**Consultation Response from KC,
Lead Local Flood Authority**
2021/90605 land at, Vanguard Processing Equipment, Spa Fields Industrial Estate, Slaithwaite, Huddersfield, HD7 5BB
Erection of an industrial building (B1(c) use)
Date Responded: 17/02/2022
Responding Officer: Martin Stephenson
Responding Ref: 0
Previous Consultation Response:

Documents reviewed by the LLFA:

Below Ground Drainage Layout

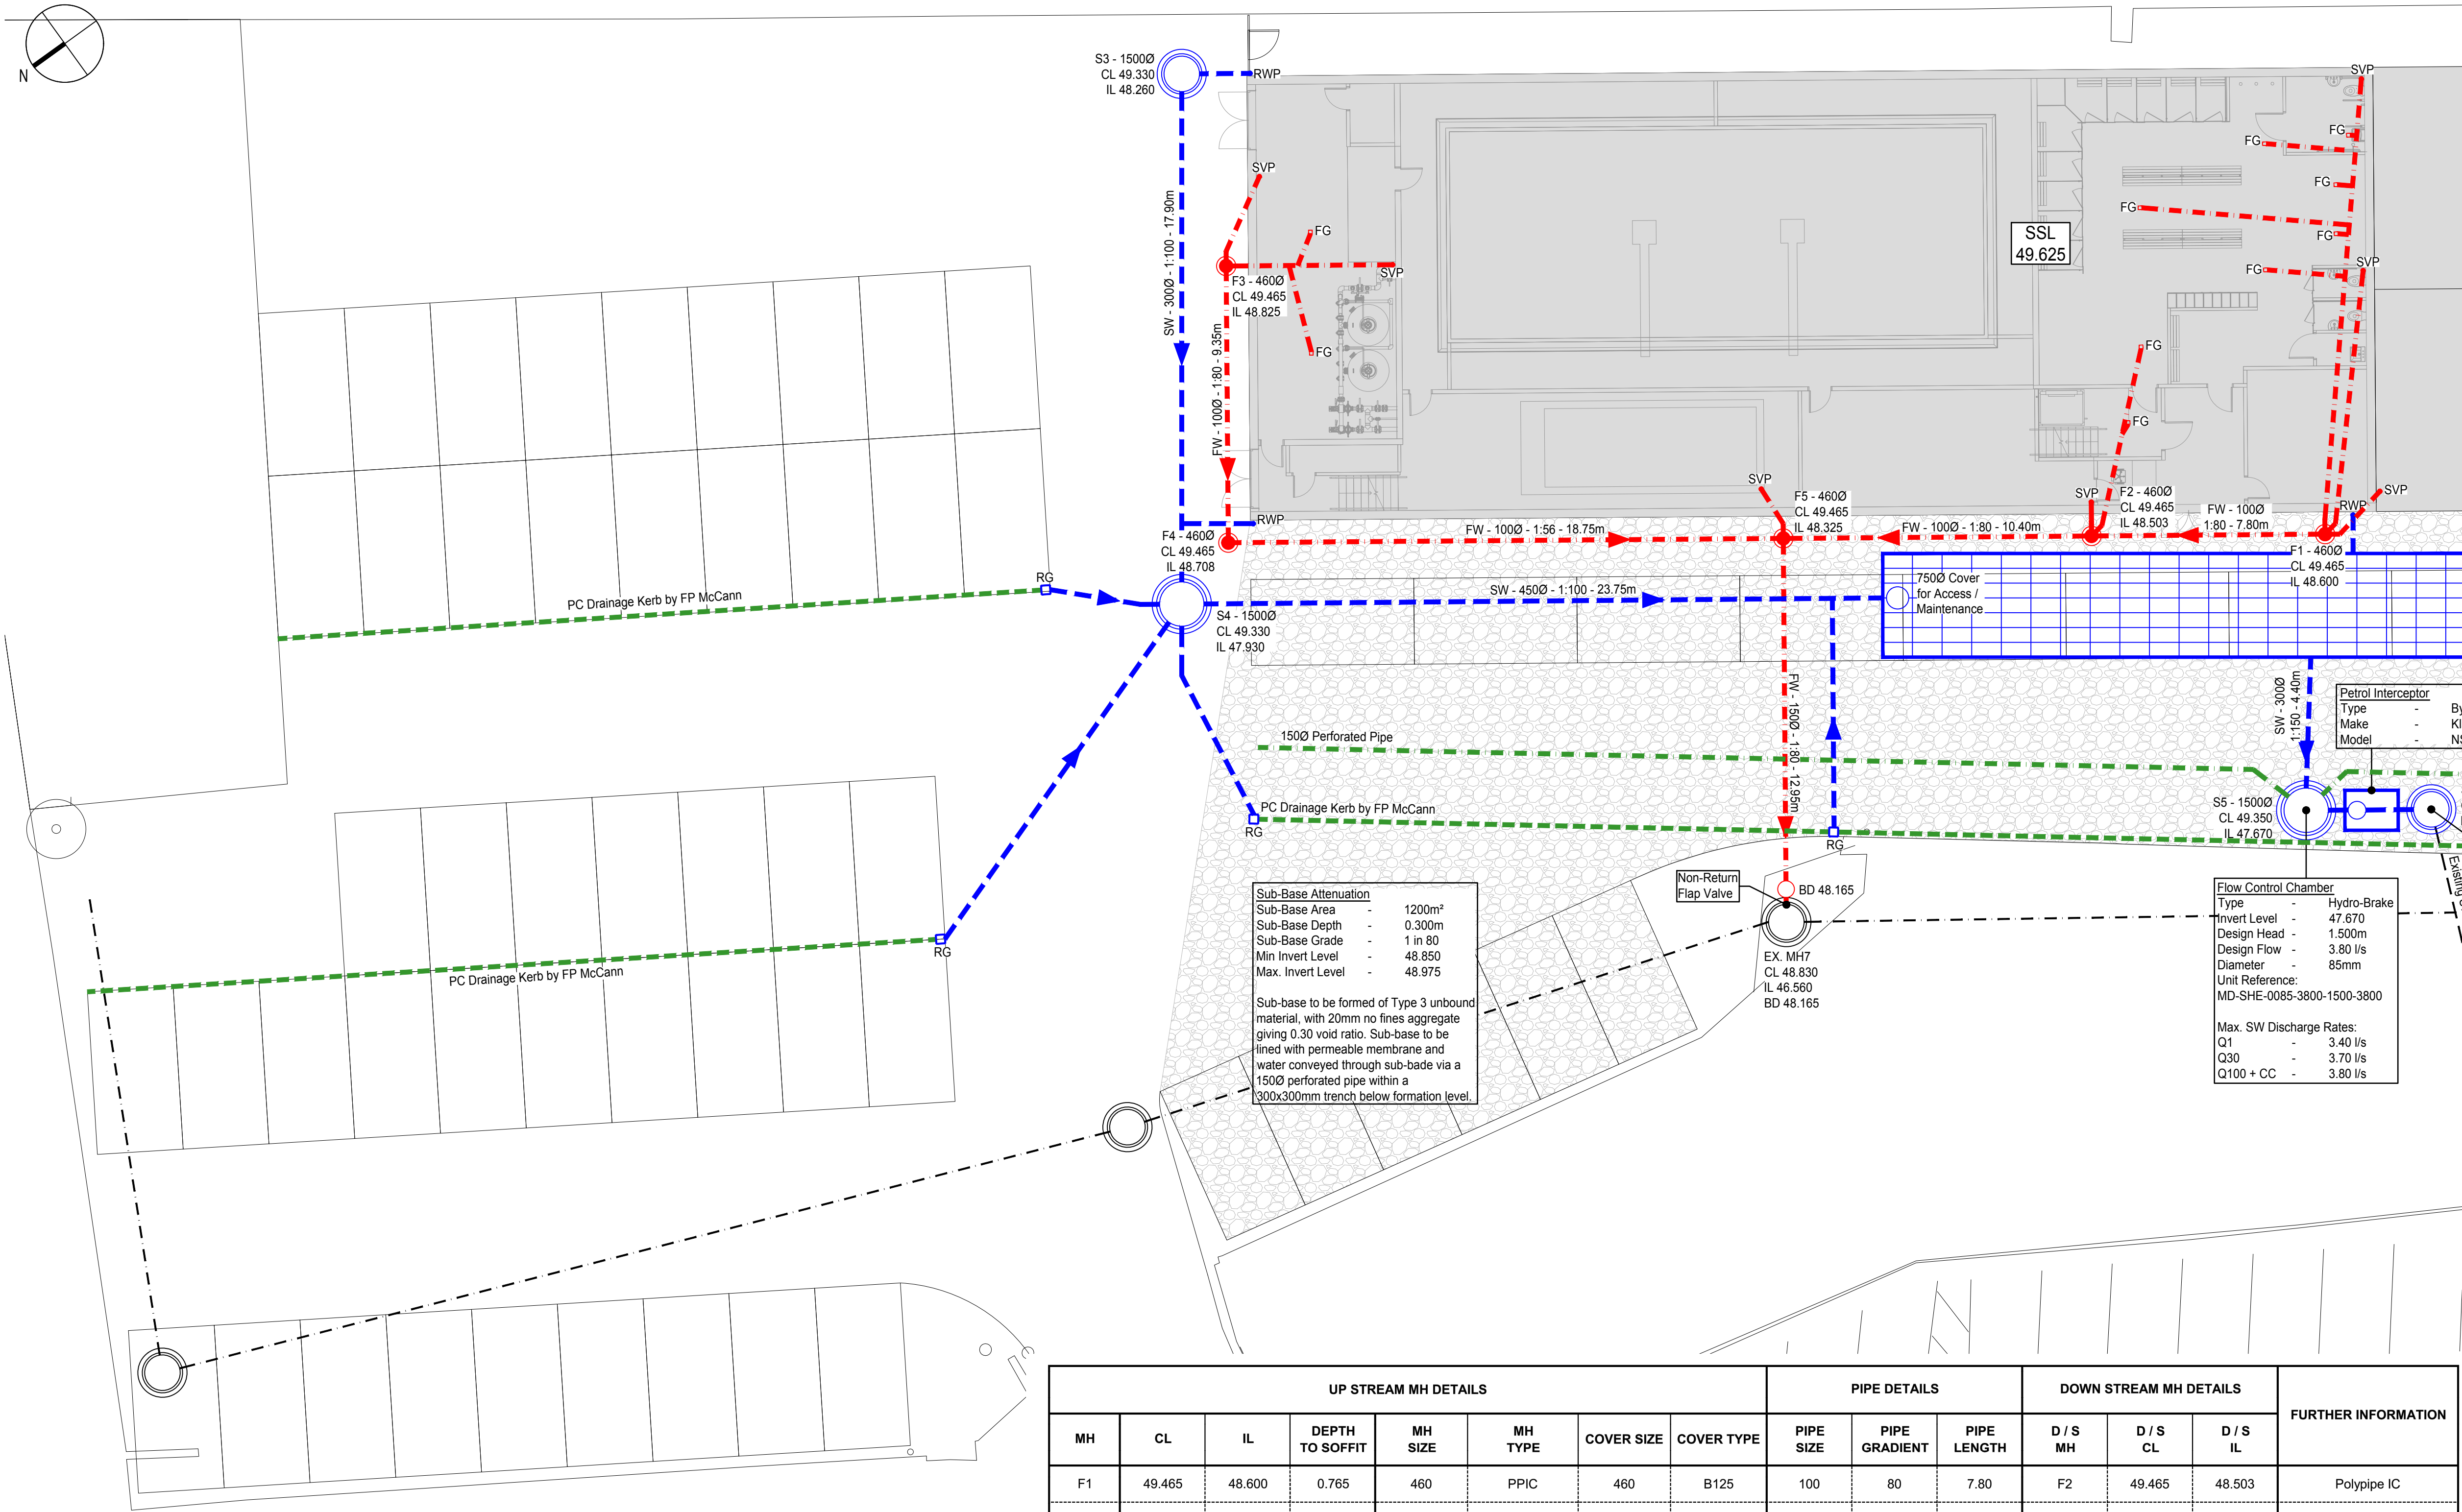
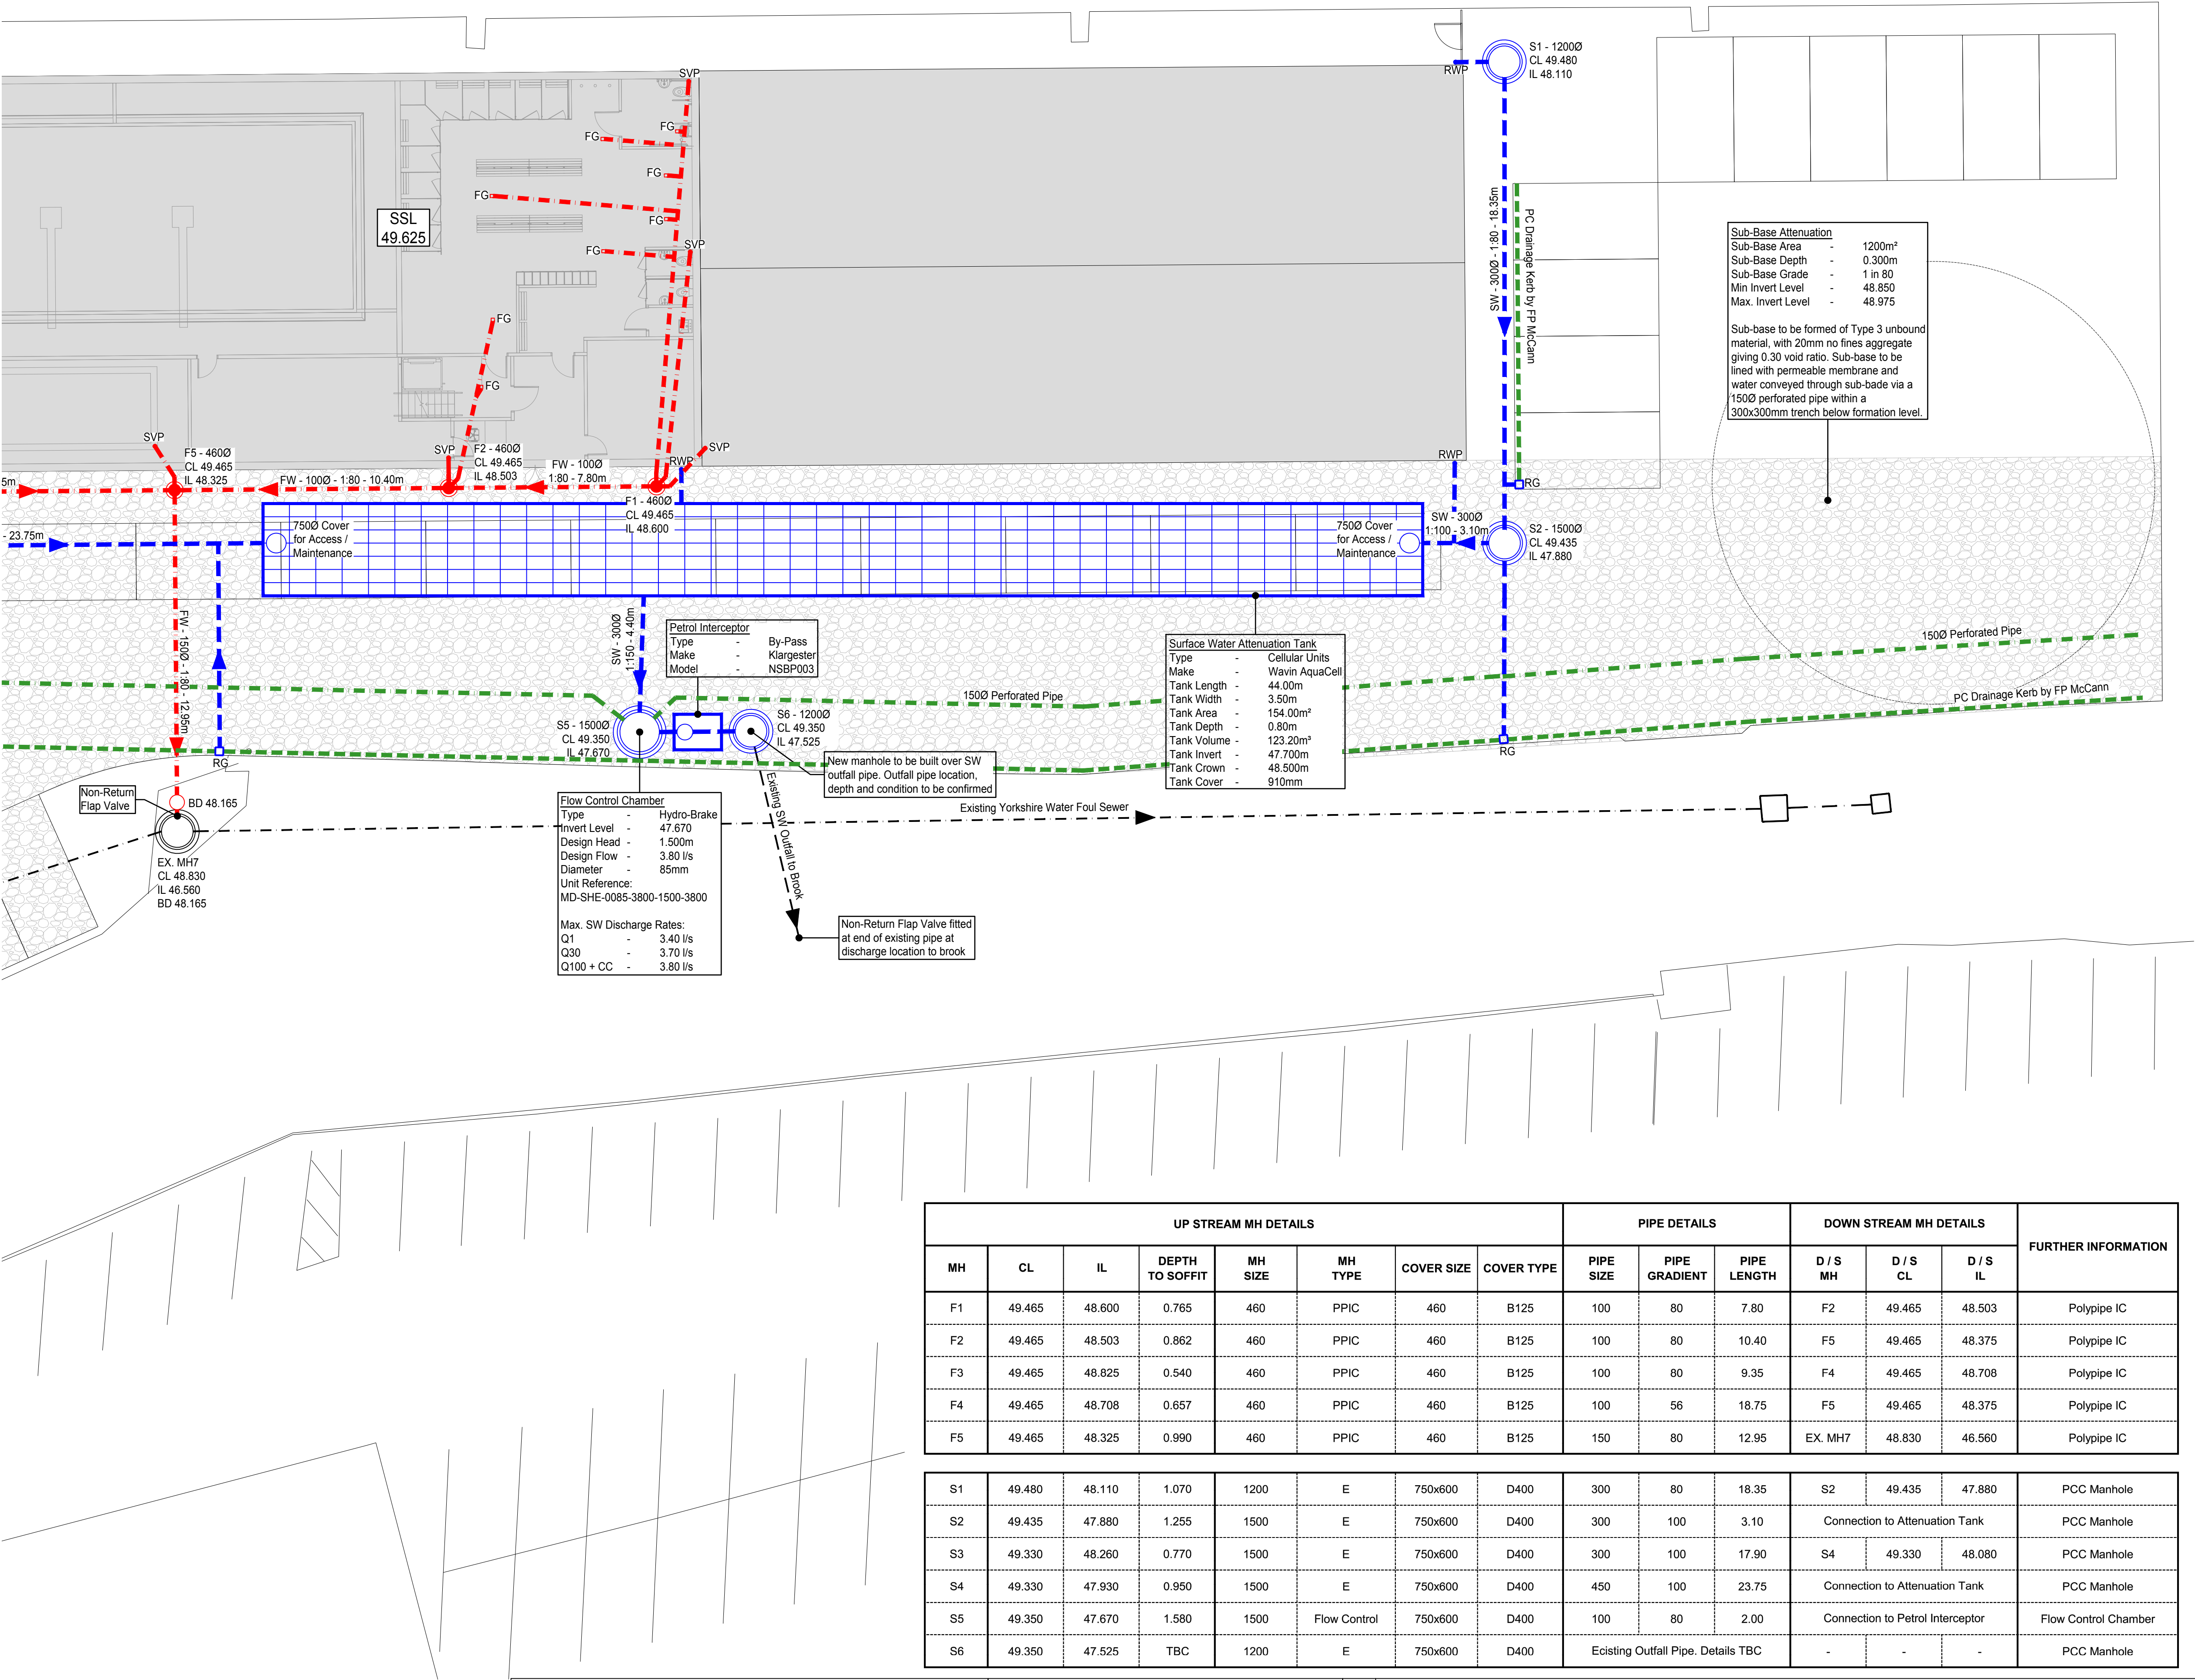
- It is noted from Kirklees Council records, that a 450mm dia Yorkshire Water Surface Water sewer crosses into the site in the south-western corner of the site. This sewer would be the preferred discharge point for the attenuated surface water flows from the site (subject to YW approvals). Discharge to a ditch as indicated on the drawing in the ICIS document would not be acceptable.

- It is noted that the drainage drawing contained in the ICIS document shows foul drainage discharging into Ex MH7 – according to our records, there is no YW Foul Sewer at this location. Please ensure the foul drainage is connected to the 225mm dia YW Combined Sewer in Spa Field (either directly or via an existing connection). Note that approval from YW may be necessary.

- The ICIS drawing also shows the oil separator receiving drainage from the roof of the proposed building – this is in contravention of good practice as these flows could flush out the separated oil. The RWP drainage should pass through the flow control device but not through the oil separator.
